From: Amanda Scholes on behalf of Planning.Responses
Sent: 17 November 2020 11:02
To: Planning Scanning
Subject: FW: Land at Stakers Farm, Yapton - Y/71/20/RES & Y/72/20/RES
Attachments: 19-156-05 Drainage Technical Note.pdf

Project Name : Stakers Farm, Yapton

Note Title : Technical Note

Drawing Title
**DRAINAGE CONSTRUCTION
DETAILS (SHEET 3 OF 3)**

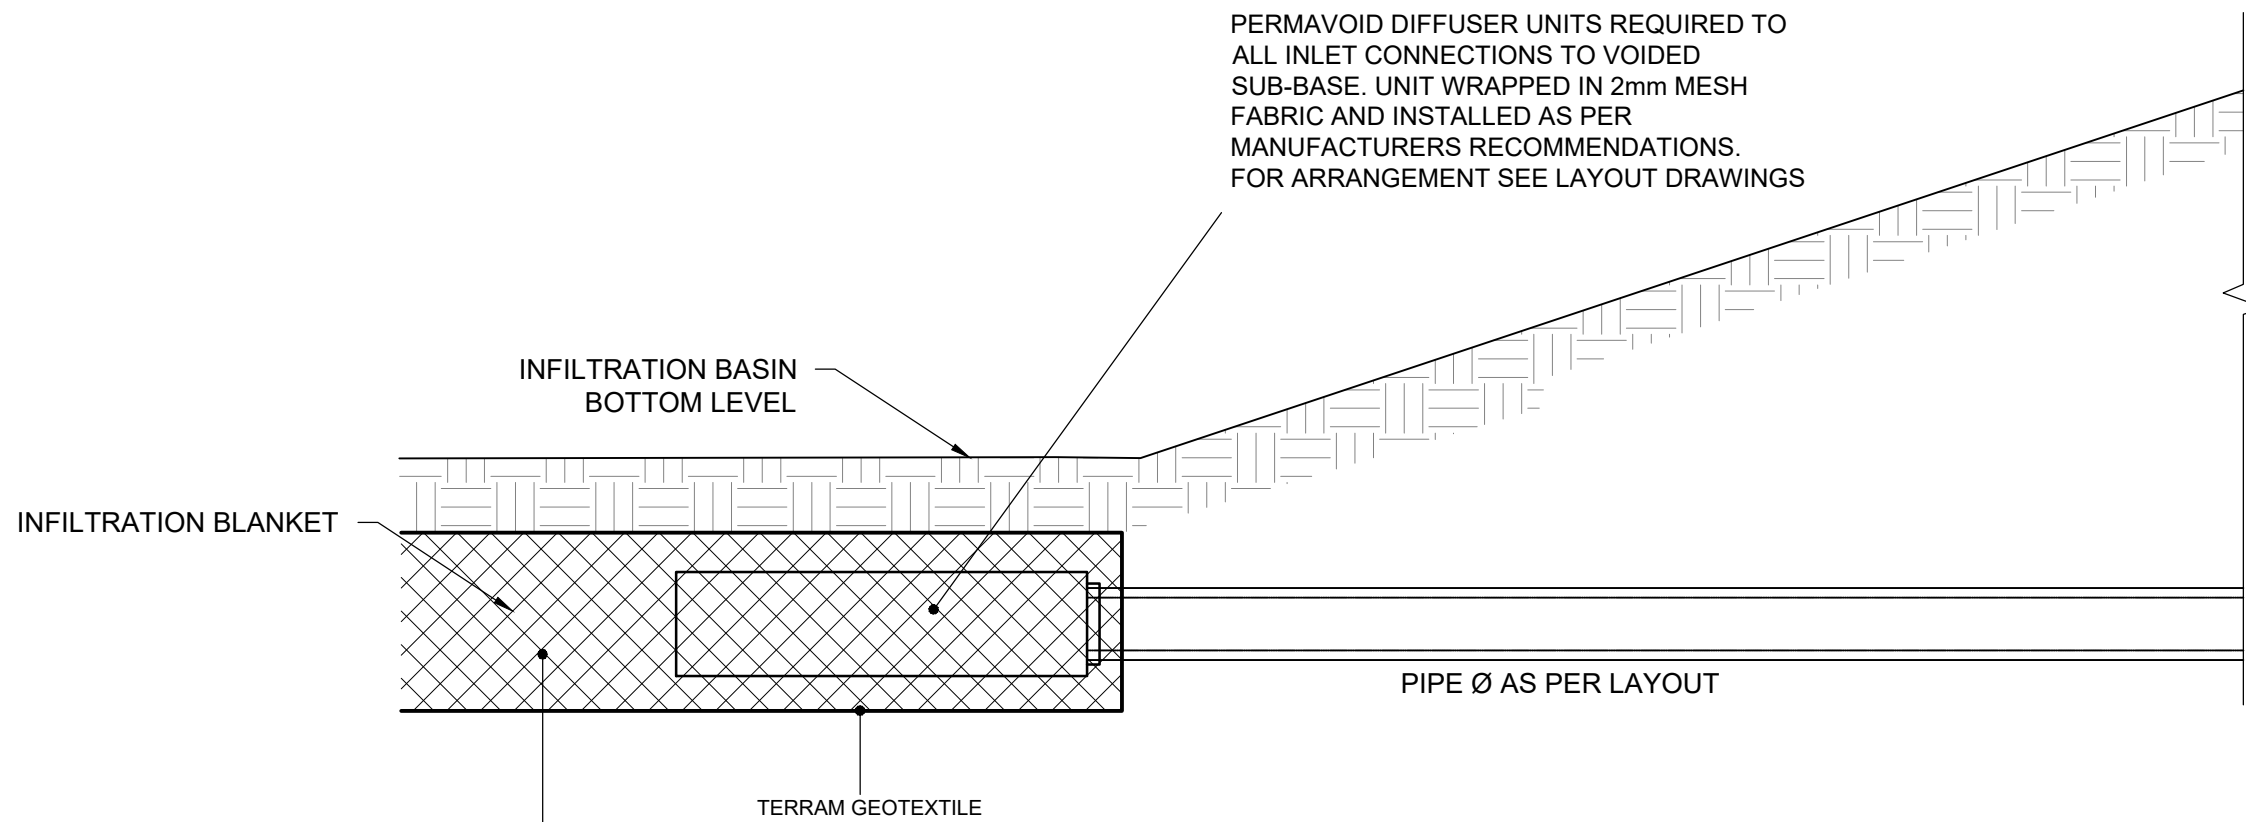
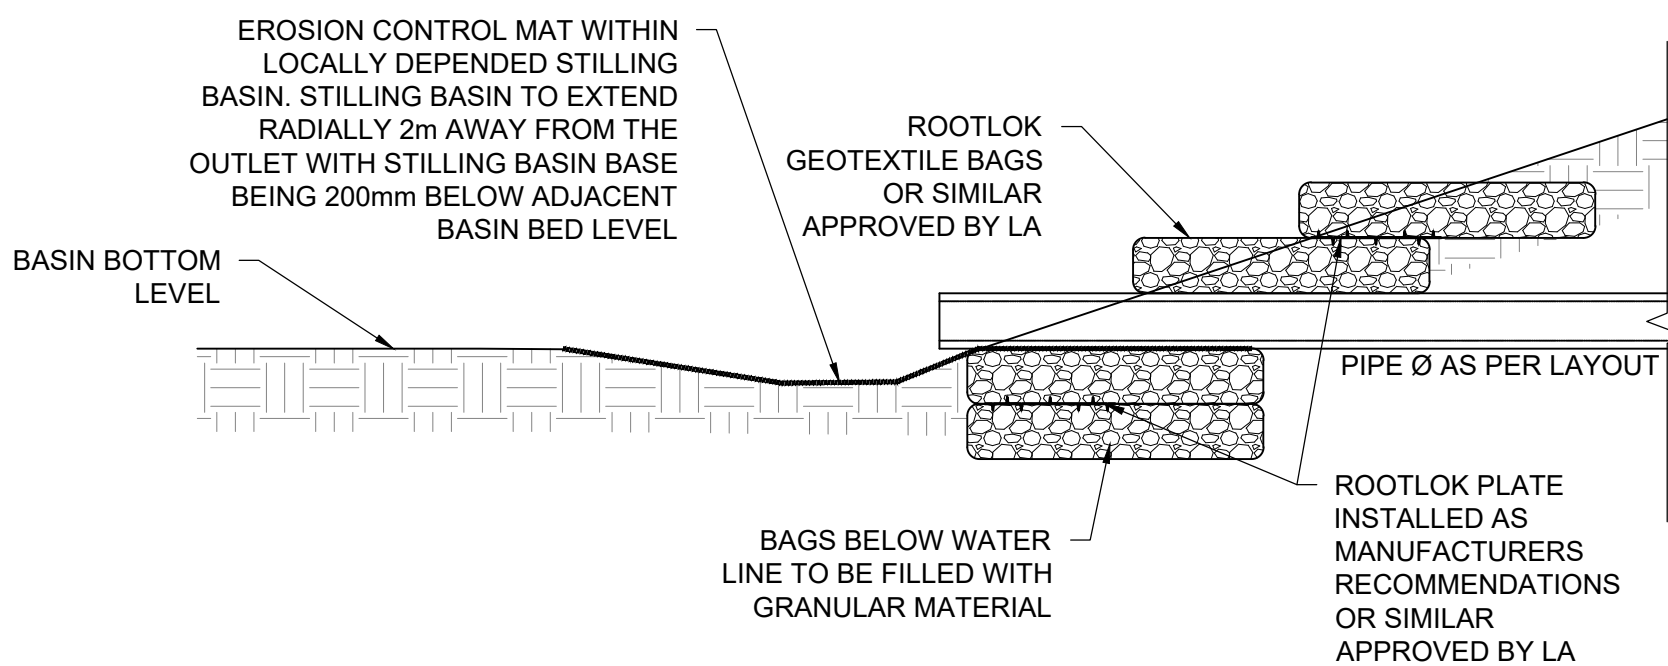
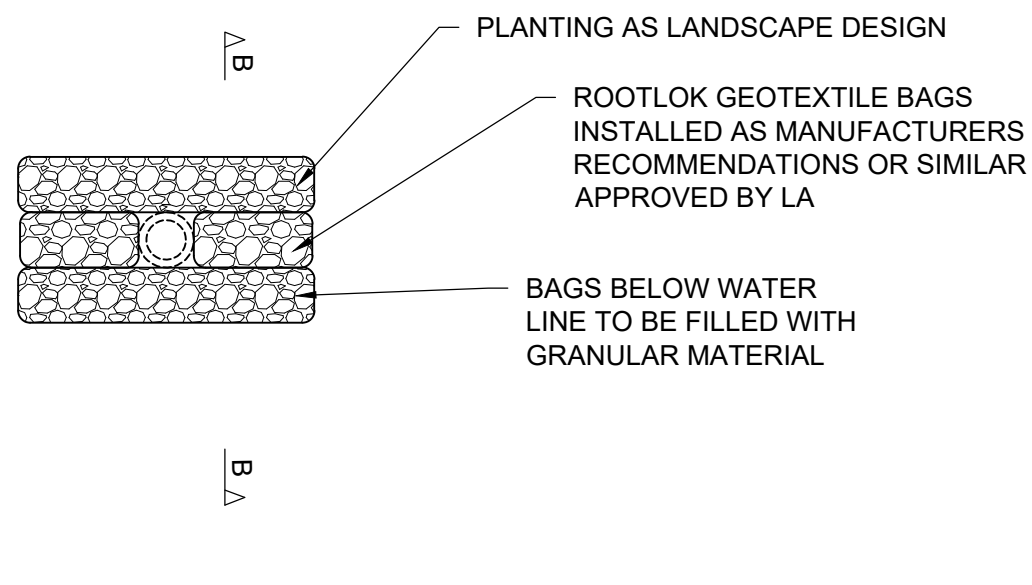
4.1.3 Arun DC Drainage engineer comment – “All SuDS features must be located outside of the utilisable open space. The LAP must not be within the basin” (comment relevant to the 38 units scheme)

4.1.4 Arun DC Drainage engineer comment – “Adequate freeboard must be provided on open SuDS features” (comment relevant to the 38 units scheme)

Odyssey response – Design is amended to use only sub-surface geocellular units infiltration storage with no surface basin. ADC comment not relevant any longer

Odyssey response – Design is amended to use only sub-surface geocellular units infiltration storage with no surface basin. ADC comment not relevant any longer
